CLAREMONT BUSINESS PARK 2 FILING NO. 2

CONSTRUCTION PLANS

JUNE 2023

EL PASO COUNTY FILE NO. VR233

**CLAREMONT BUSINESS PARK 2 FIL. NO. 2
 STREET IMPROVEMENT PLAN**

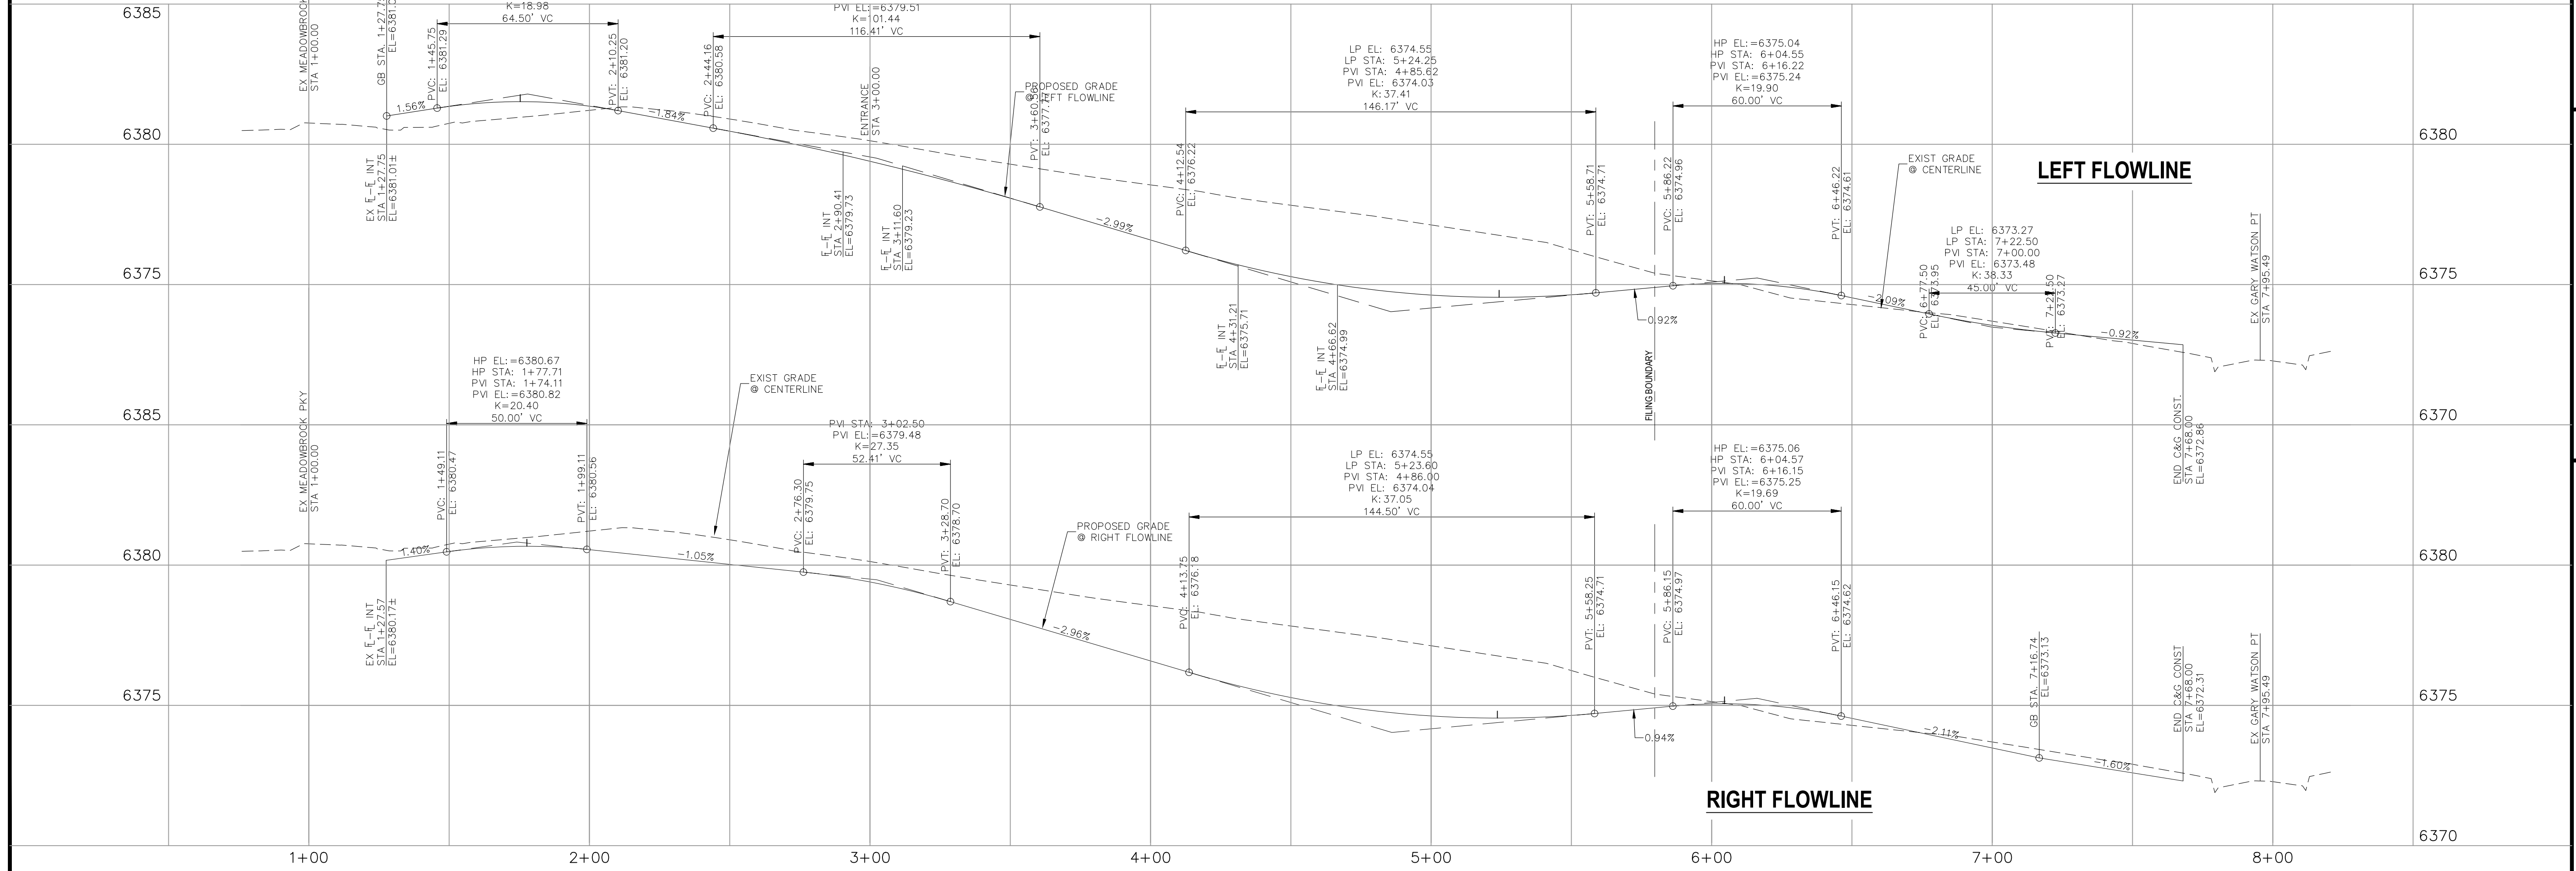
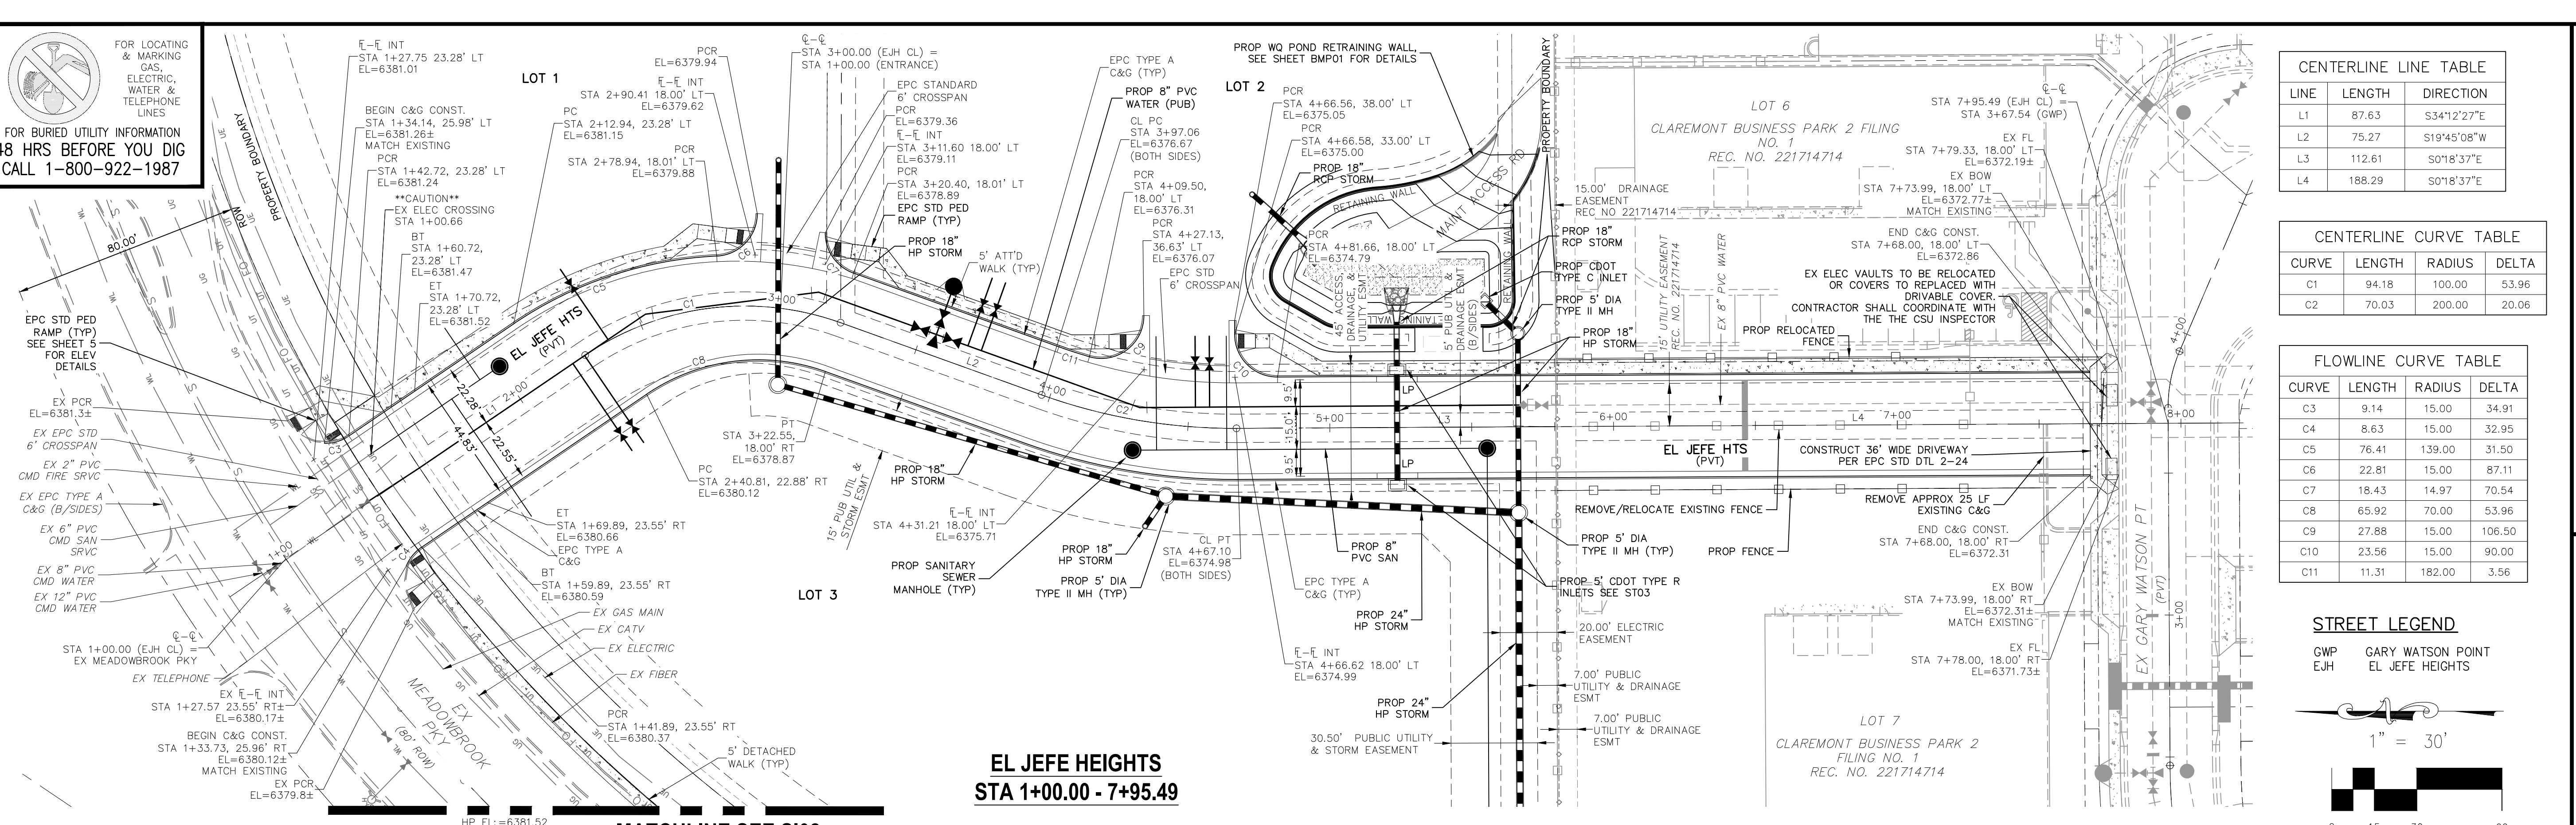
Label this line or turn off.

This line is the 7" public utility & drainage easement on the other side of the property line and has now been labeled.

CLAREMONT BUSINESS PARK 2 FIL. NO. 2
 SIDEWALK & INTERSECTION DETAILS
 PROJECT NO. 10-020
 SCALE: HORIZONTAL: VERTICAL: N/A
 DATE: 06/01/23
 DESIGNED BY: GW
 DRAWN BY: CLP
 CHECKED BY: VAS
 SHEET 5 OF 14
 S102

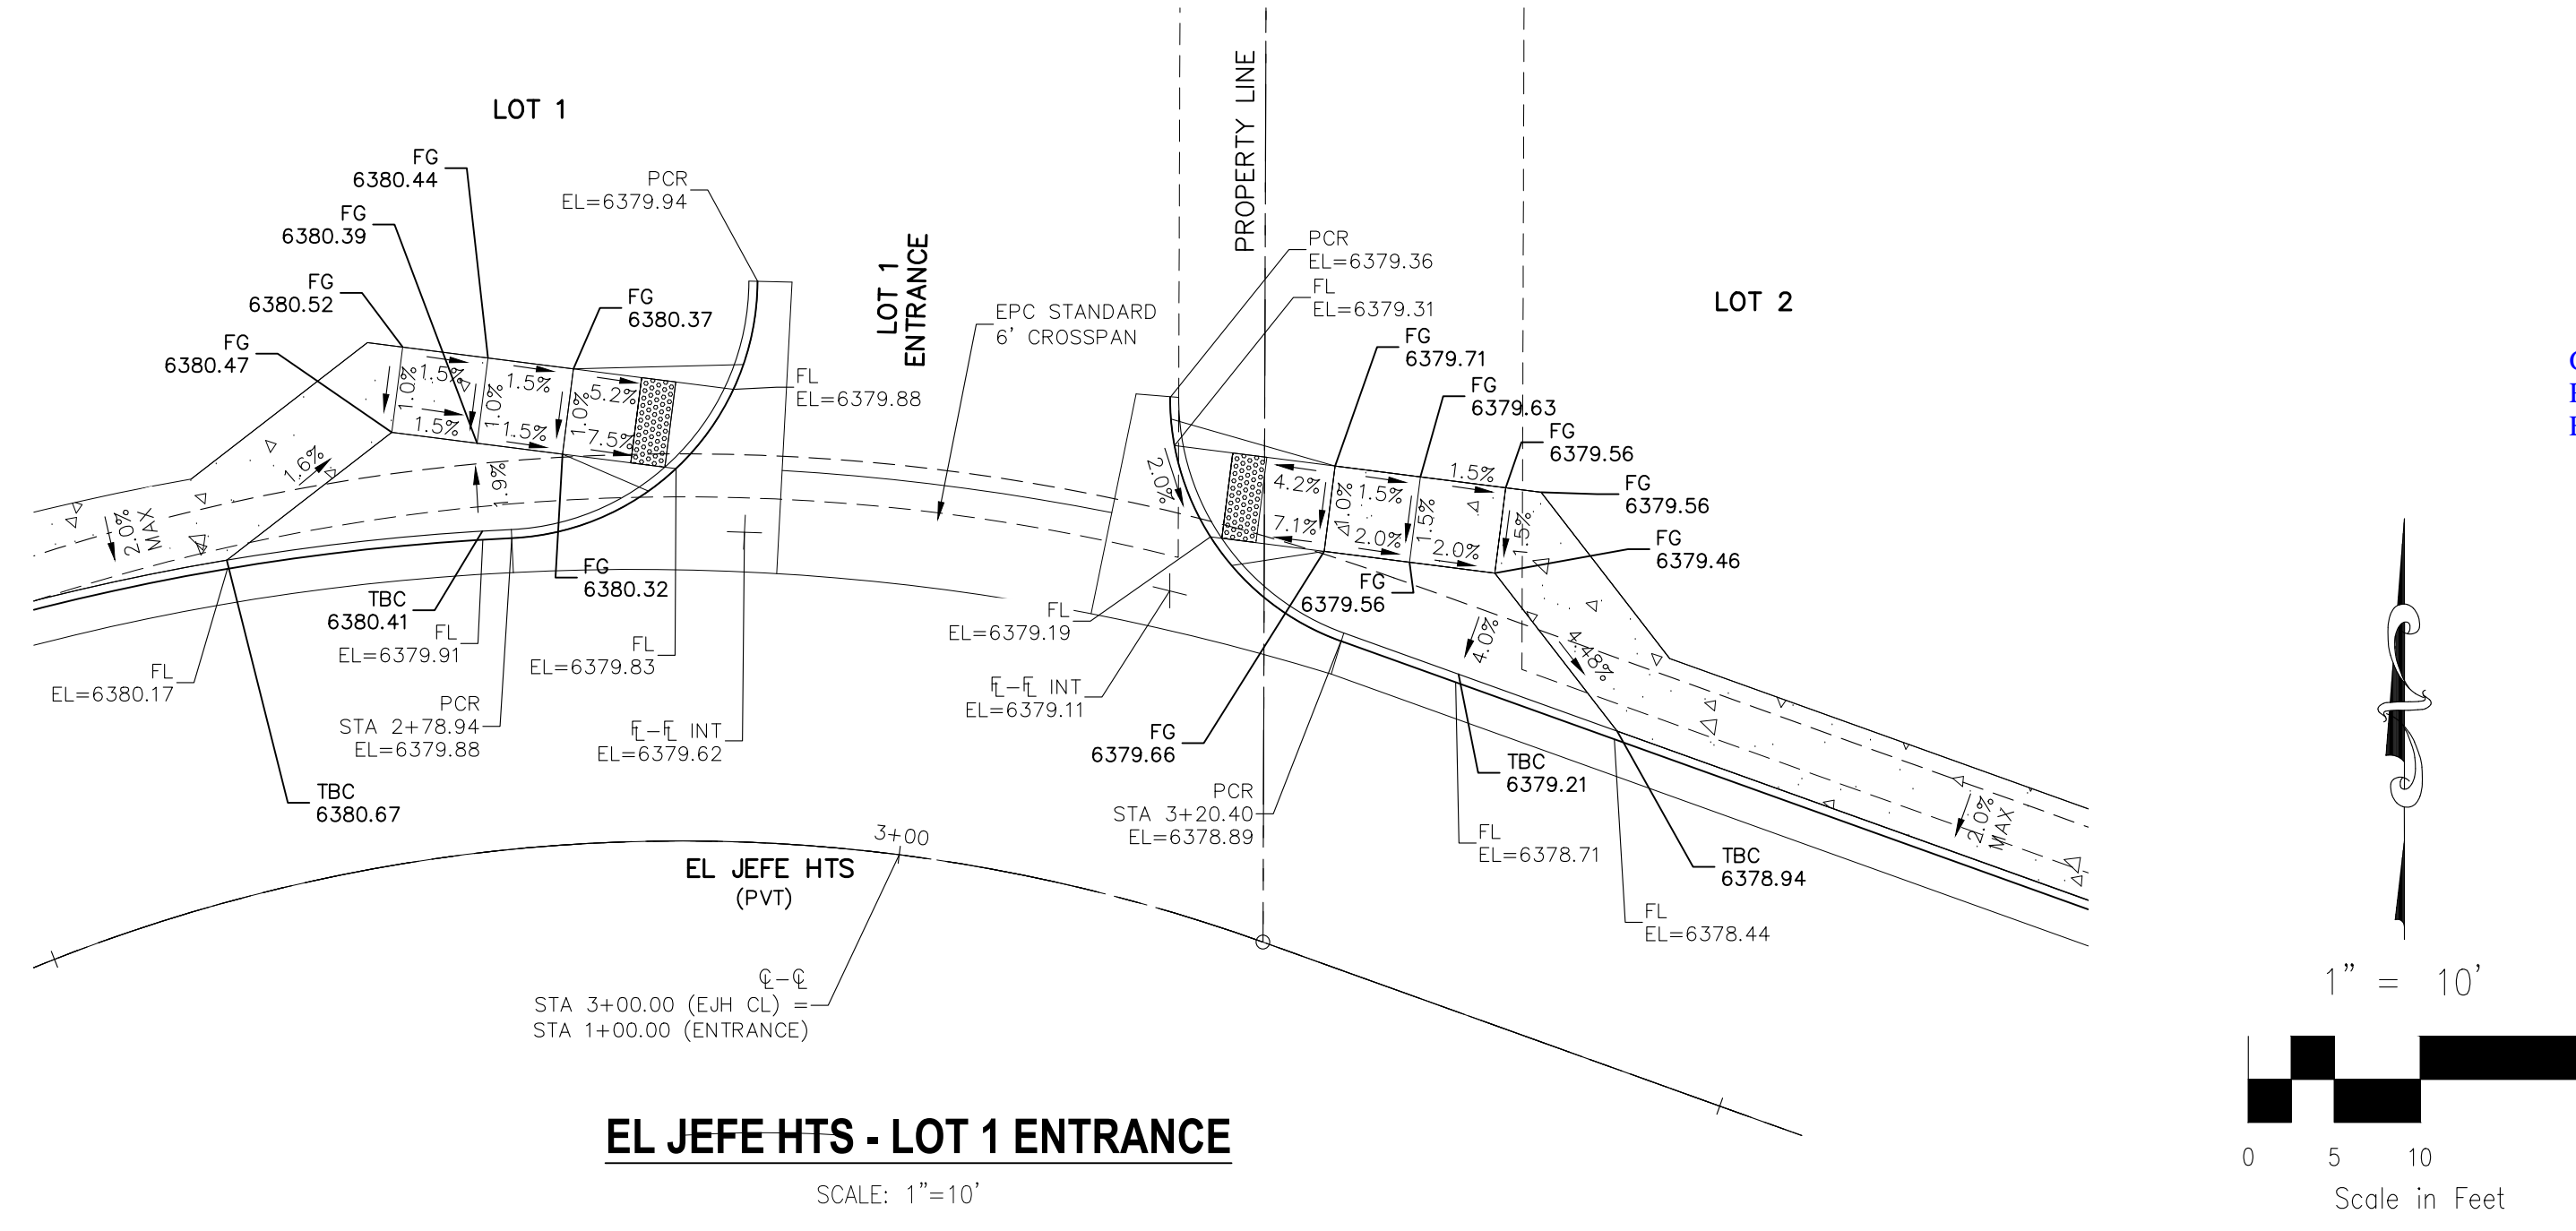
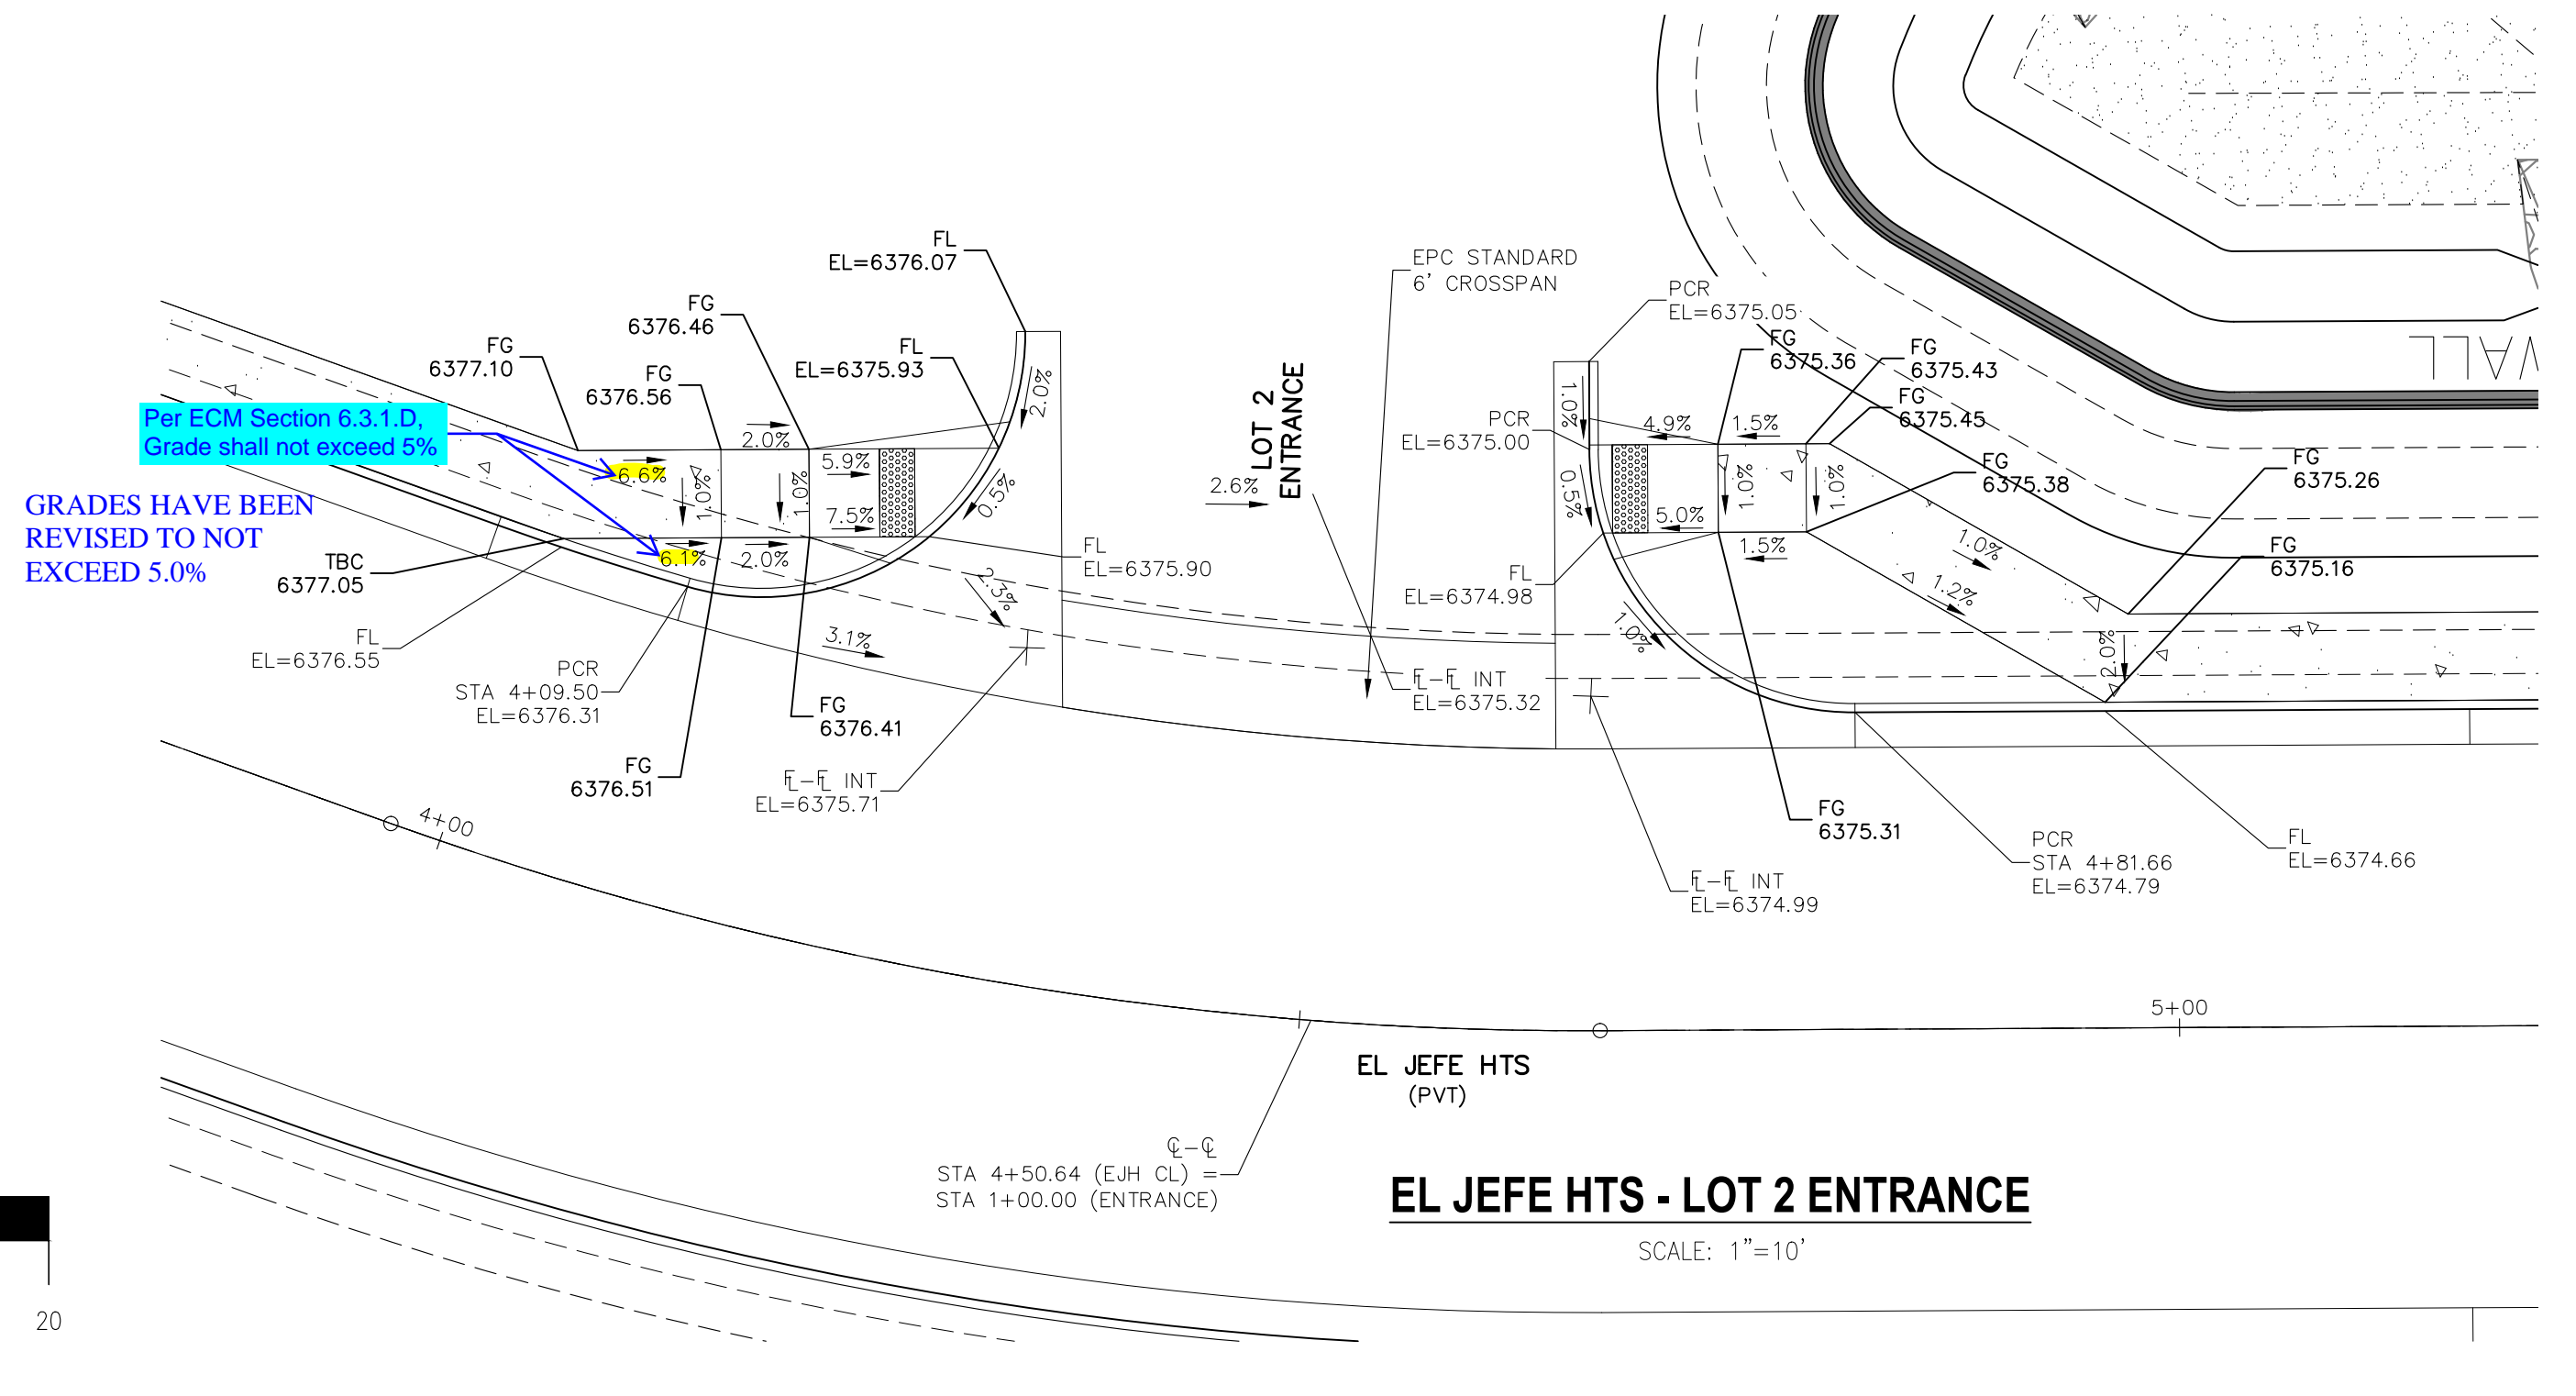
This has been labeled as existing and temporary.
 Label as existing and temporary.
 Label this line or turn off.
 This line is the 7' public utility & drainage easement on the other side of the property line and has now been labeled.

The slope across the cross walk has been added
 Provide slope across El Jefe Hts. through cross walk
